Our ref: D3.25.0100

**App no: 25.0100**

**Address: Land at The Eagle at Barrow Clitheroe Road Whalley BB7 9AQ**

**Proposal: Proposed hotel development comprising two-storey building (use class C1) with associated parking and landscaping, bin store, air conditioning units and new pedestrian access.**

Drawing no.	FB ref.	revision
2023/91/02	2023/91	G

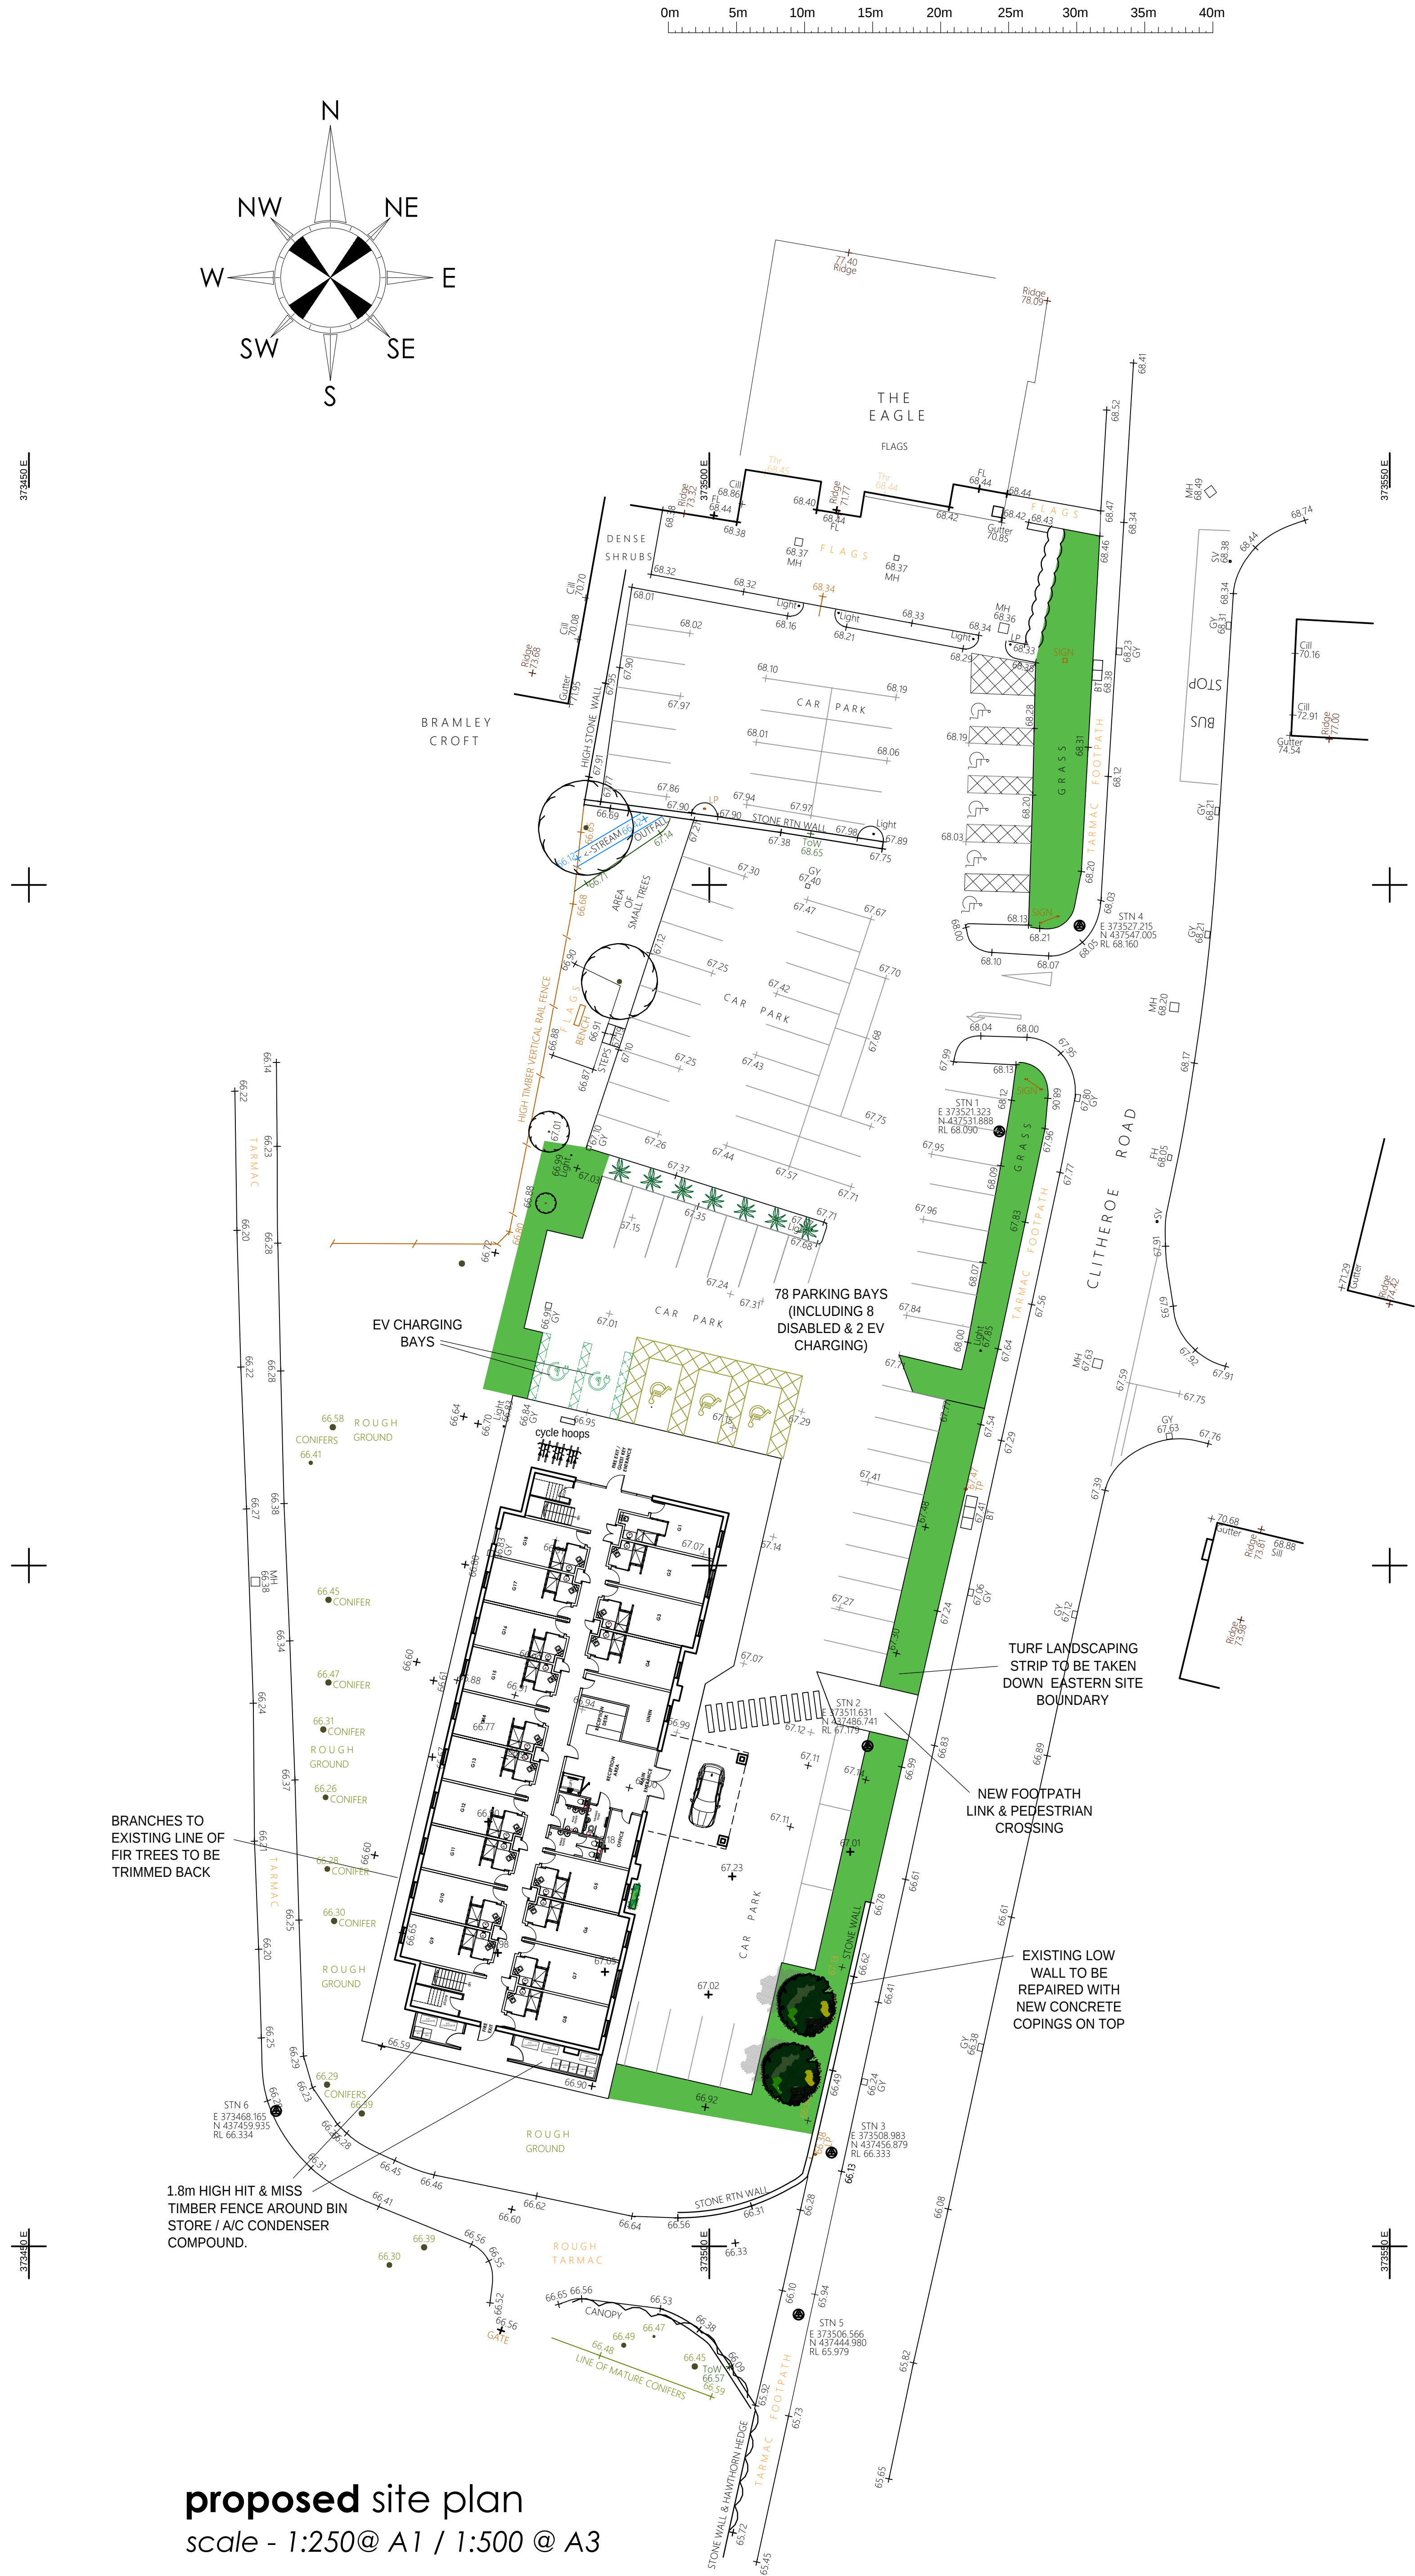
We would request that tactile paving is added to the site access dropped crossing points.

There is no provision for a coach, we would request this this is addressed to confirm or otherwise if this is likely to be required at the site.

There are 8 disabled parking spaces and 2 electric vehicle charging spaces proposed, these should be 10% of the overall provision. There are 6 bicycle parking spaces (3 sheffield stands) proposed and these stands will need to be covered and secure and

increased to 10% of the car parking provision. Motorcycle parking is required at 4% of the car parking provision.
